## Thomas FitzGerald - Online Submission from Michael Connelly (object)

**I Michael Connelly of 15 Parkes Lane Terranora, wish to object to the development proposal No.09\_0166 - Residential subdivision, by Newland Developers (formerly Metricon Queensland) Pty Ltd on the following grounds:**

METRICON (QLD) PTY LTD
 ALTITUDE 1 - FRASER DRV. TERRANORA
 BUILDING PAD LAYOUT & SECTIONS
 Sheet 3 of 3

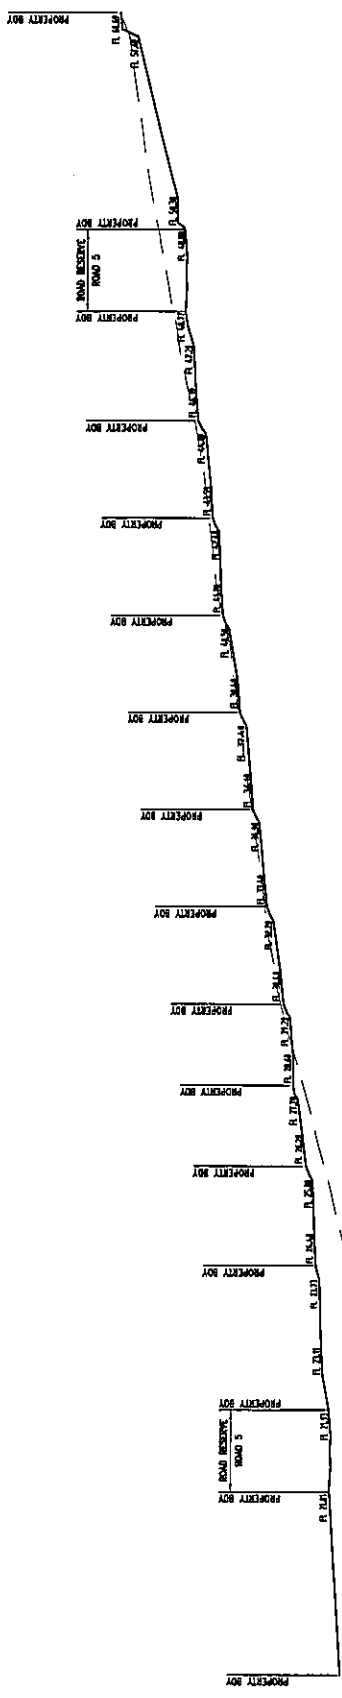
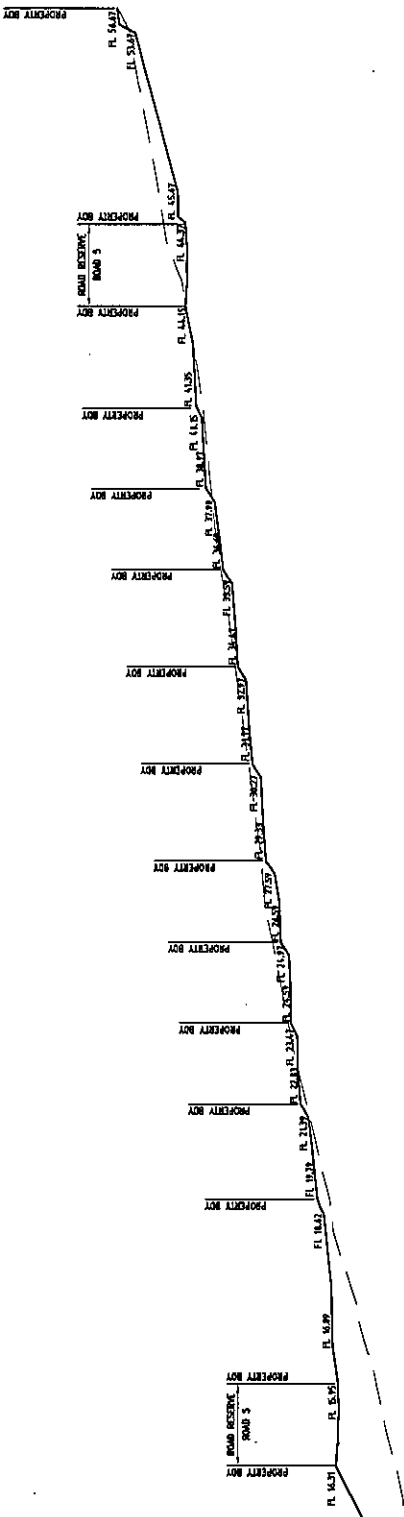
The preliminary retaining wall plan prepared by Brad Lees Consulting (SK2712) shows that almost every allotment has retaining walls on at least 3 of its boundaries. There is also a 3metre high retaining wall along the entire Fraser

Drive boundary and two 3metre high walls on the boundary with properties in Parkes Lane creating an imposing 6metre high wall. As well as being in contravention to Council landforming policy, these walls will create a visual eyesore which has once again been ignored in the Visual Impact assessment prepared by LVO Architecture.
